# ENG-SF21021-R1-Plat.pdf Markup Summary

RETREAT AT TIMBERRIDGE
FILING NO. 2
JOB NO. 1185.20
JANUARY 4, 2021
SHEET 4 OF 7

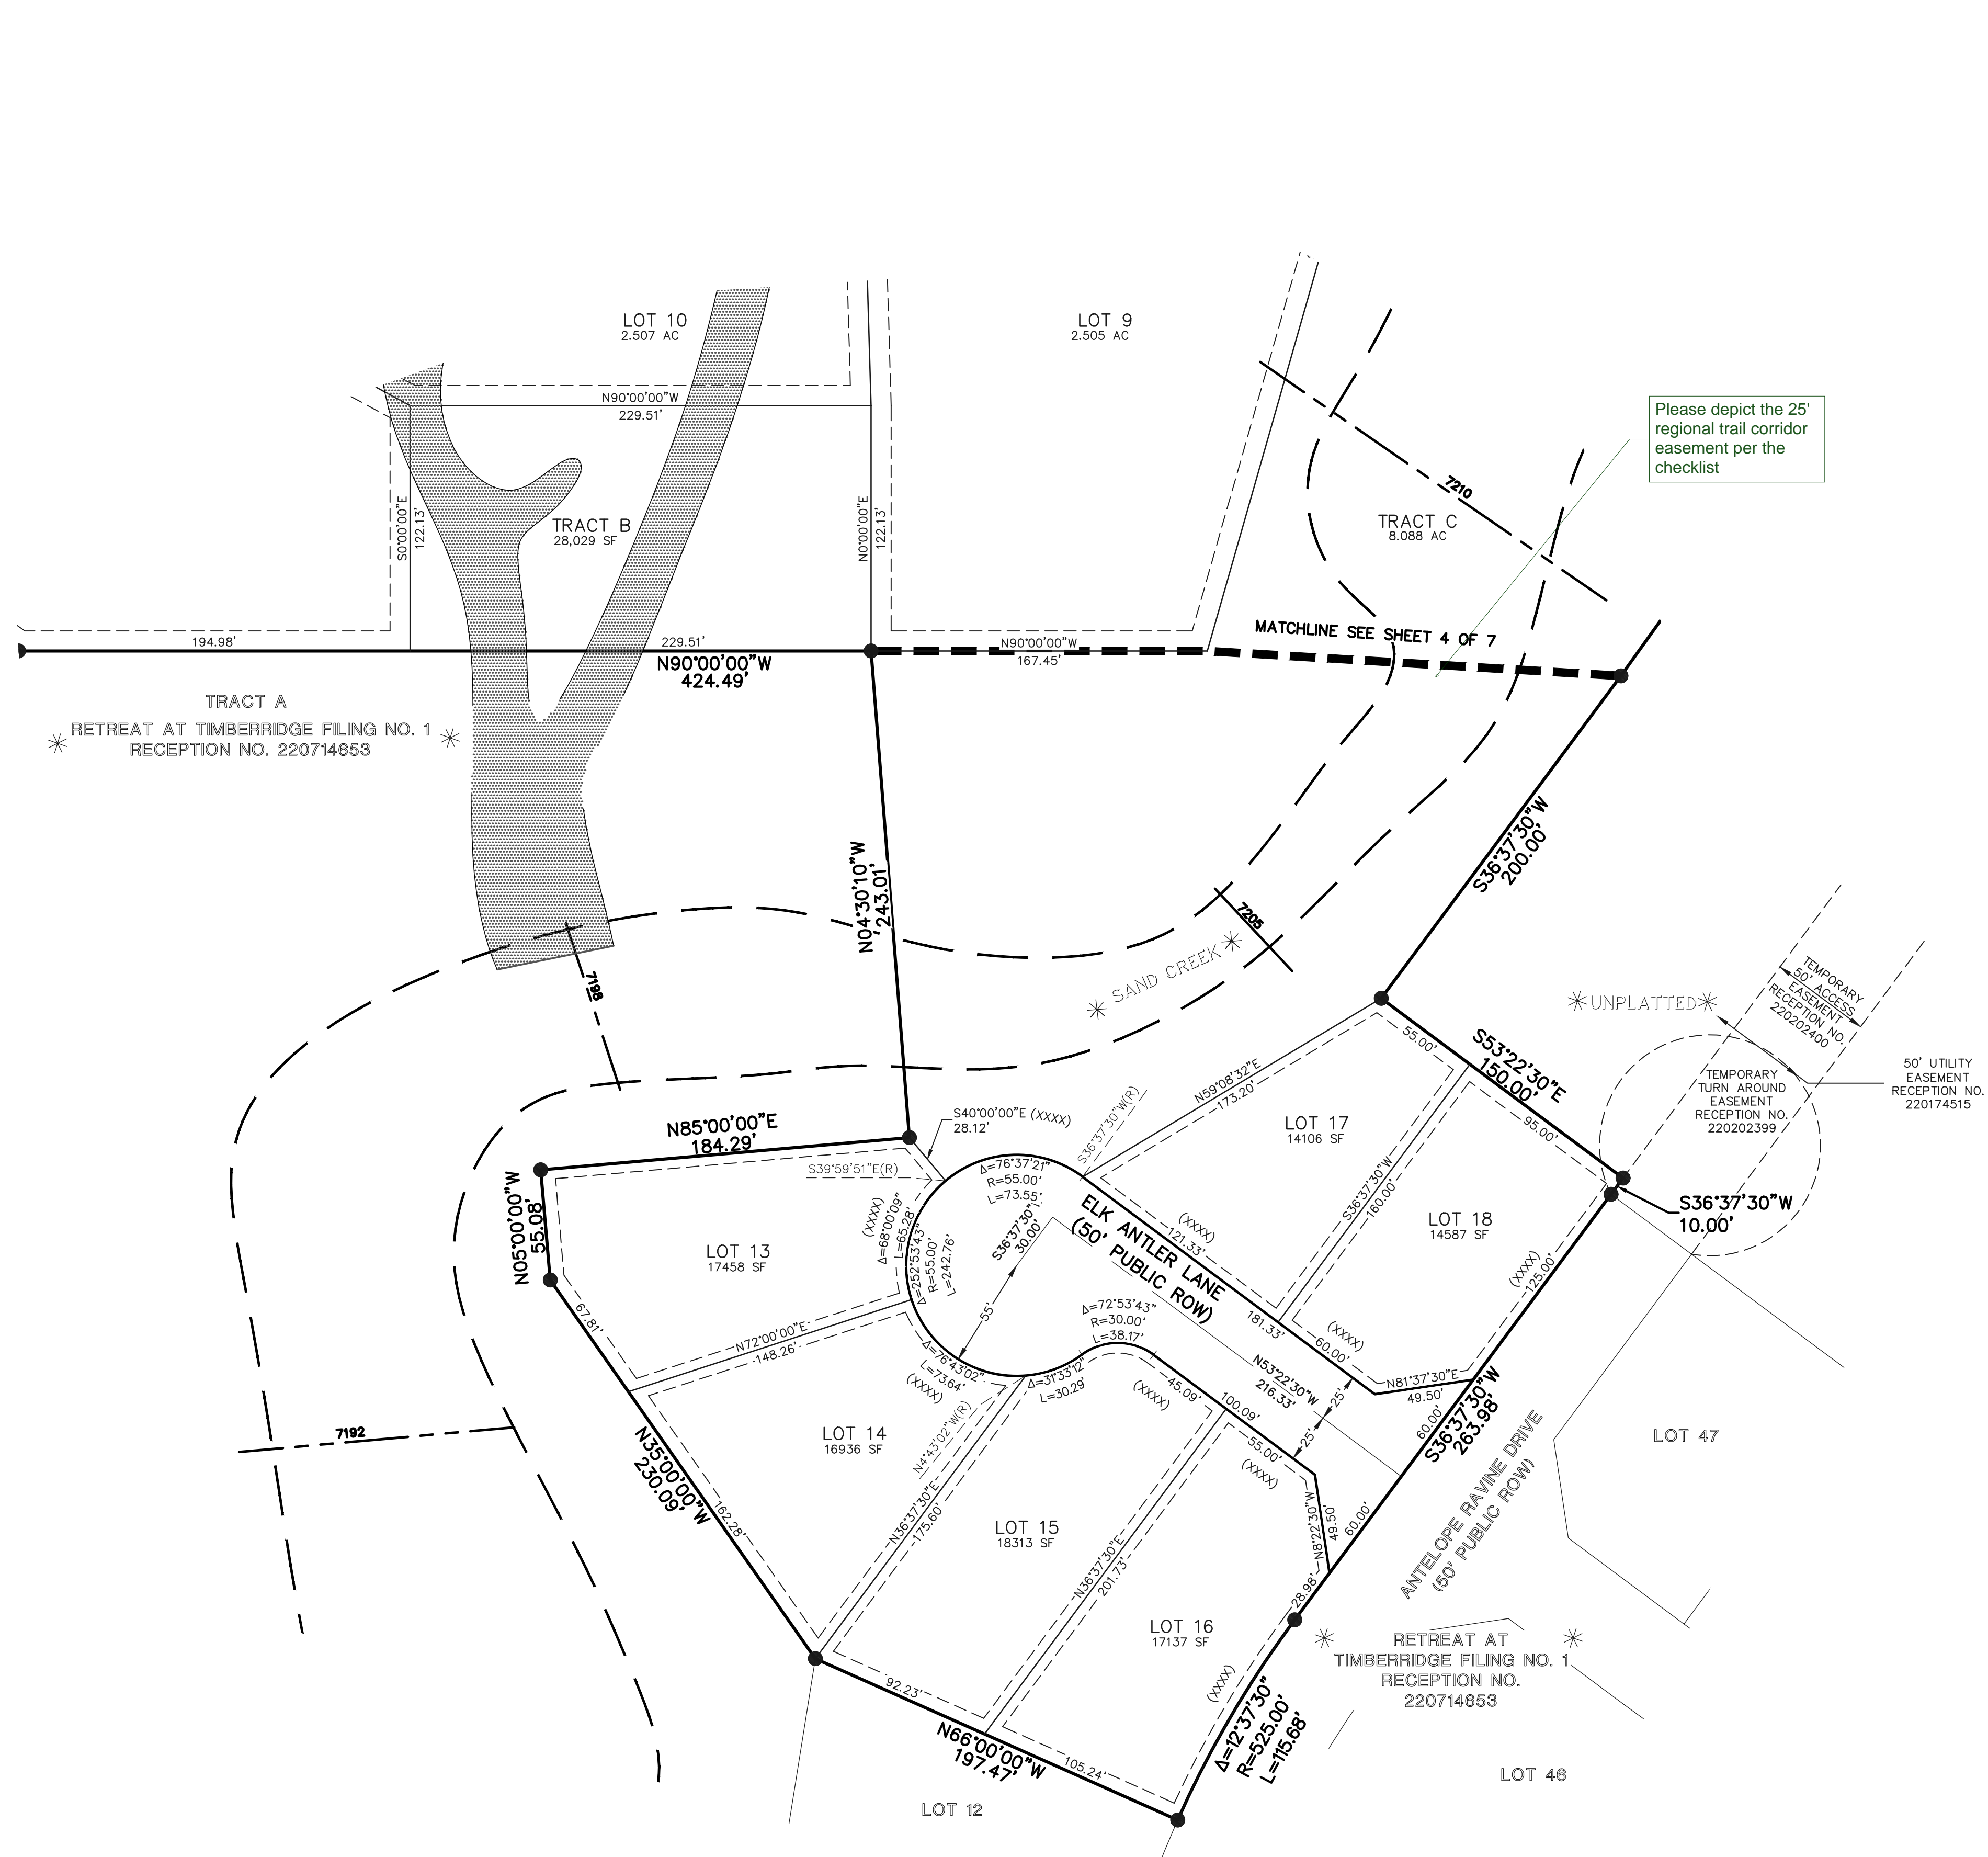
Please depict the 25' regional trail corridor easement per the checklist

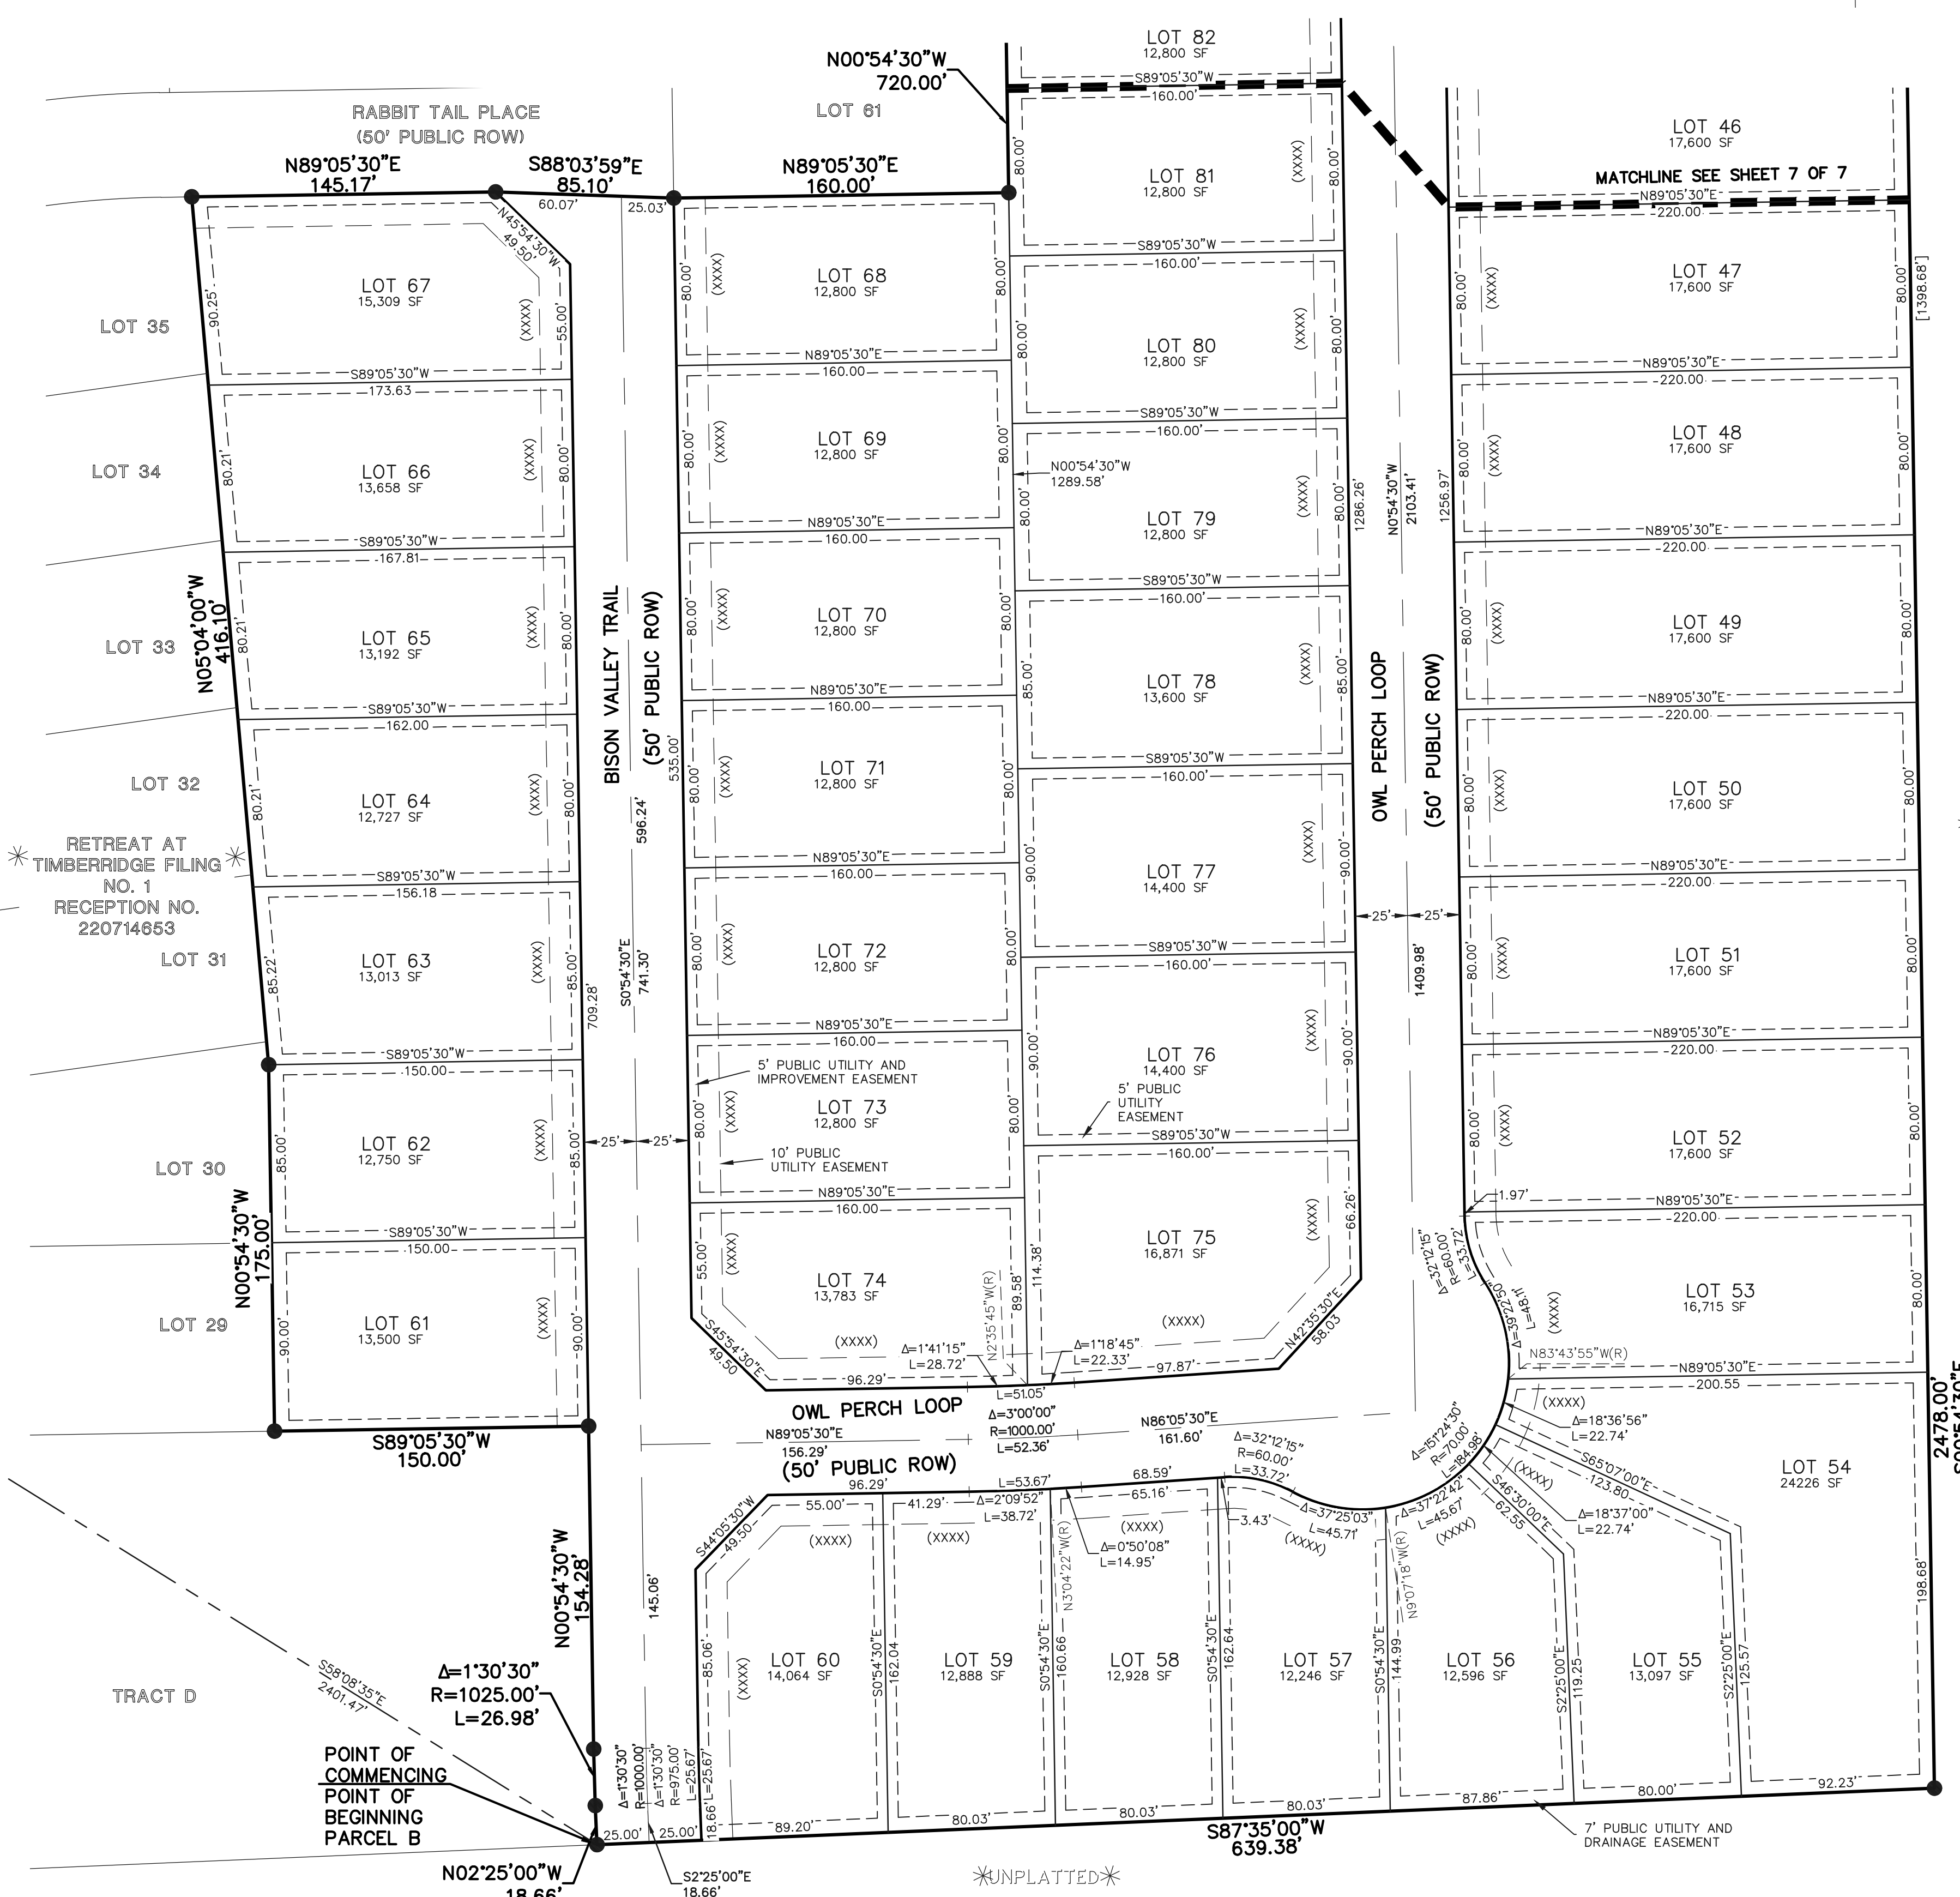
Please depict the 25' regional trail corridor easement per the checklist

RETREAT AT TIMBERRIDGE
FILING NO. 2
JOB NO. 1185.20
JANUARY 4, 2021
SHEET 6 OF 7

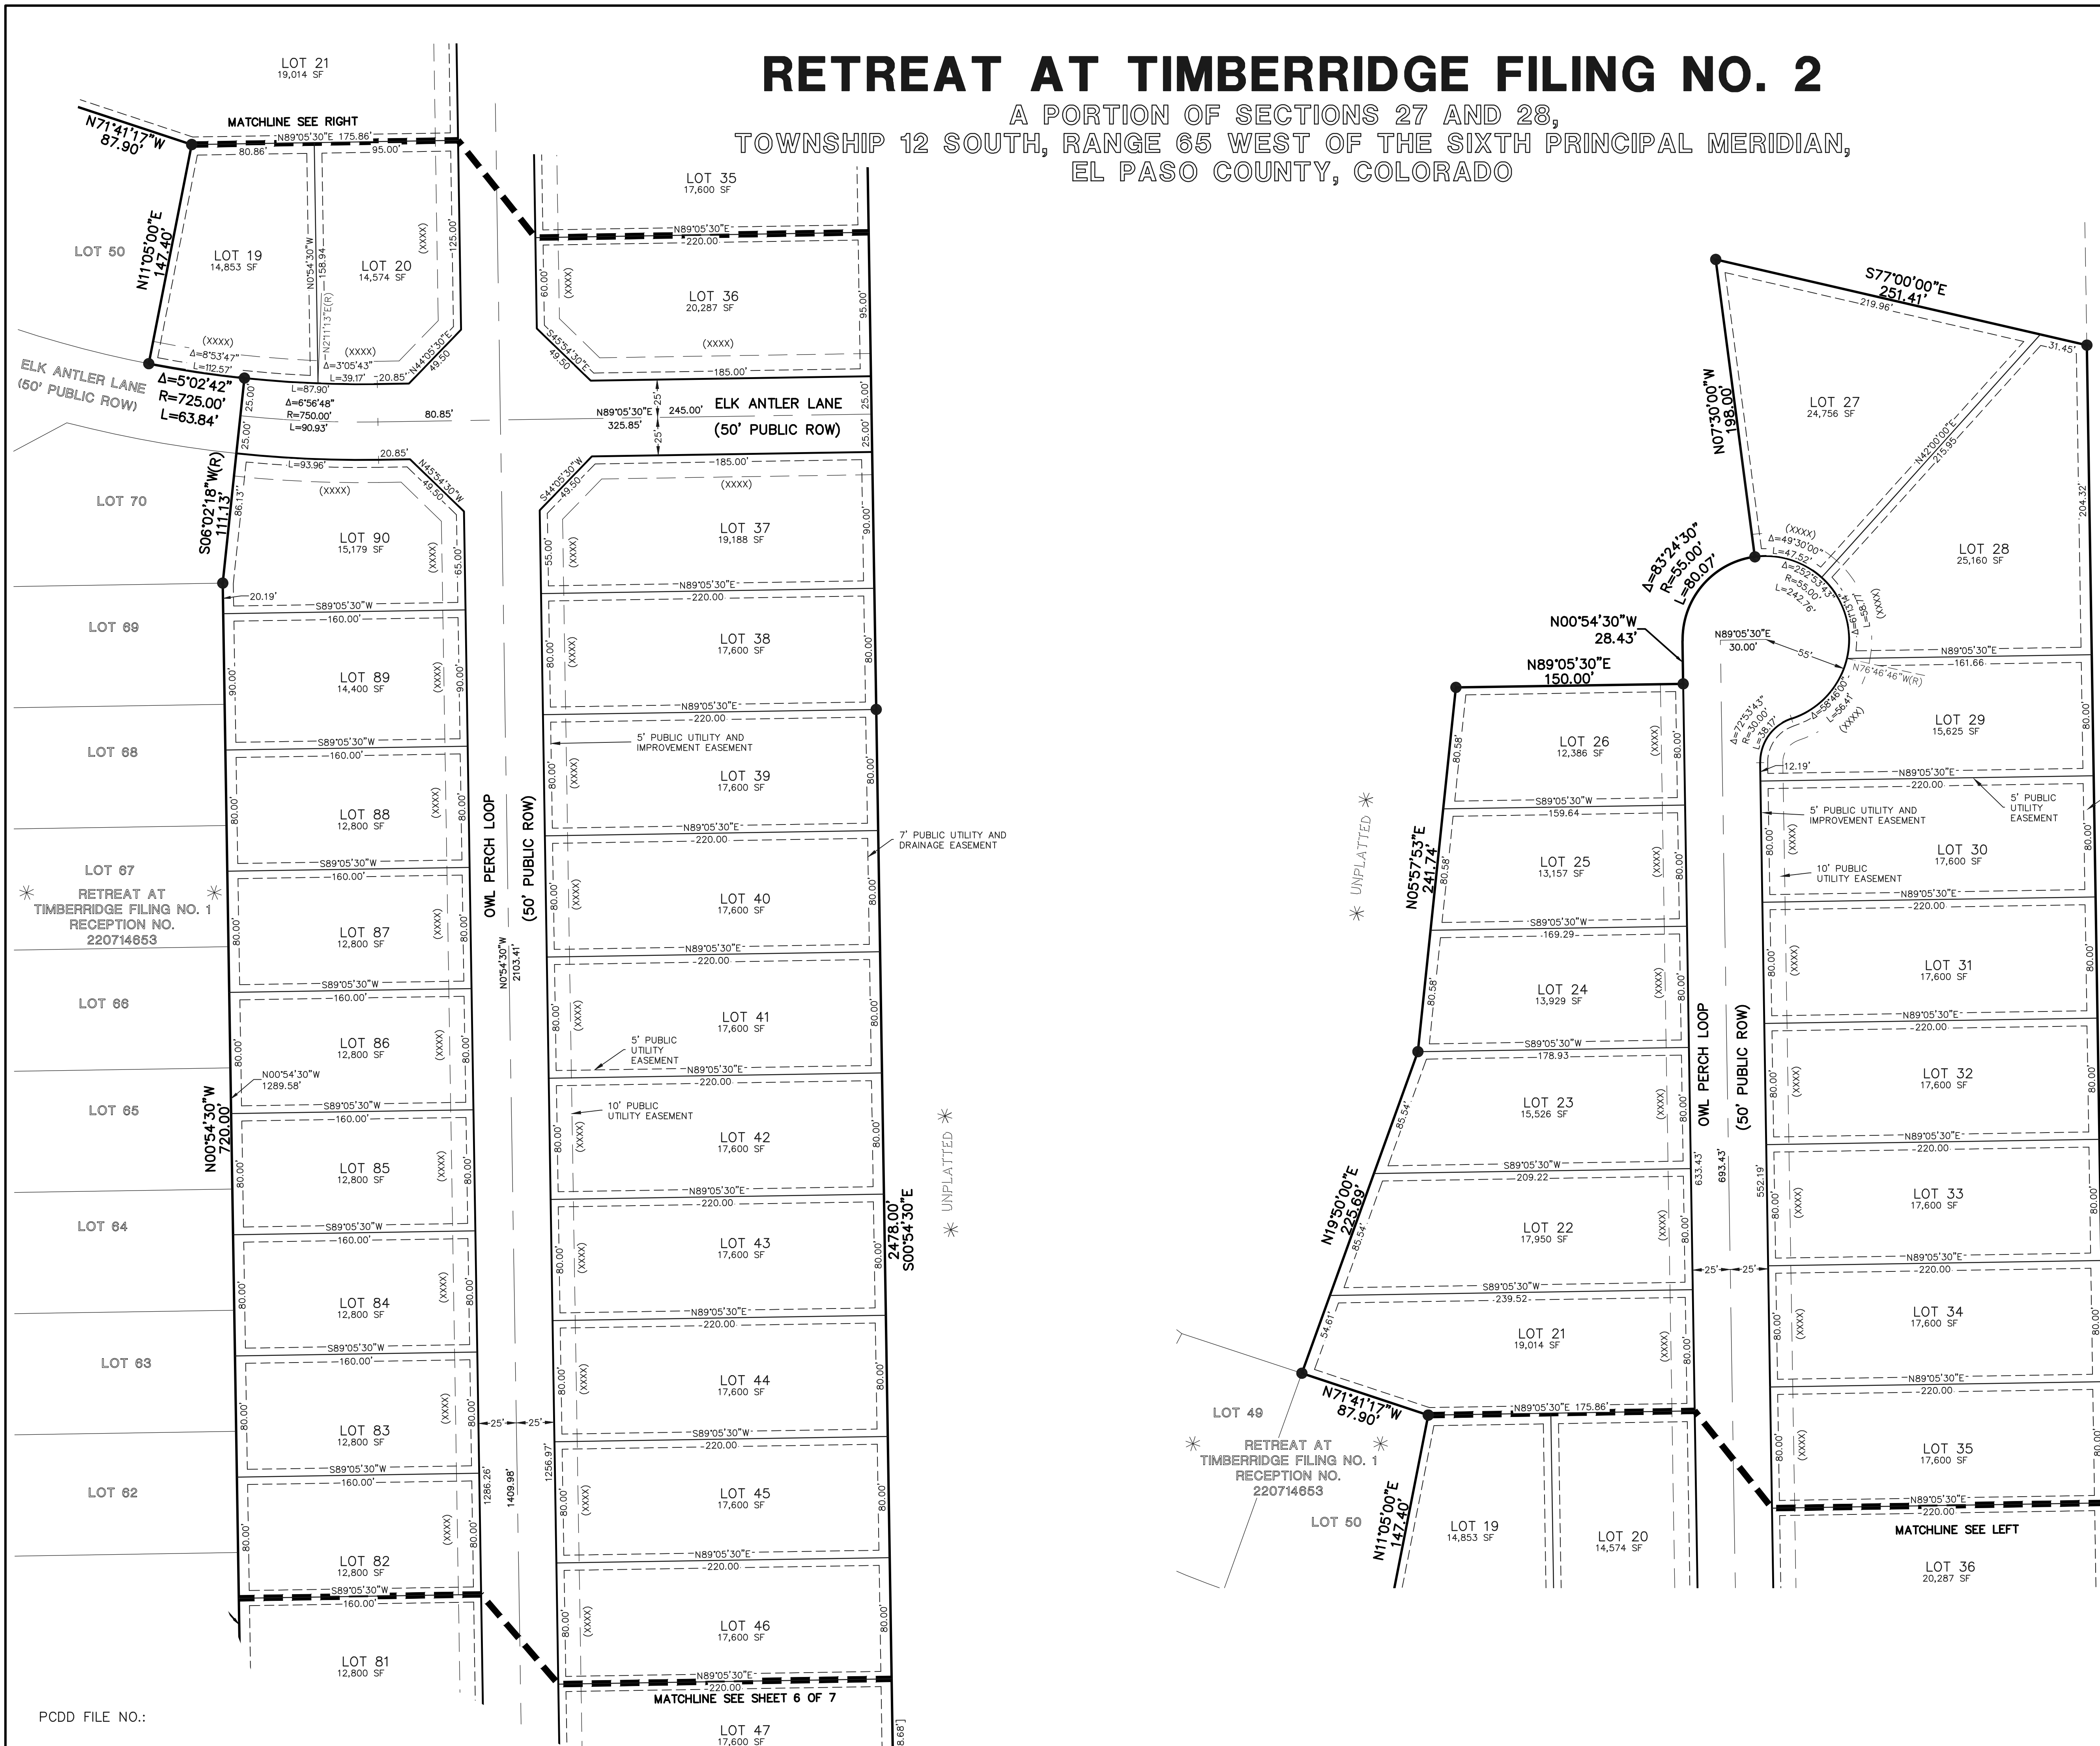
please provide fencing in FAE per the PUD, also provide a note on plat (district to maintain fence) Developer will install?

Fencing needs to be outside of the necessary drainage easement - address in FDR.
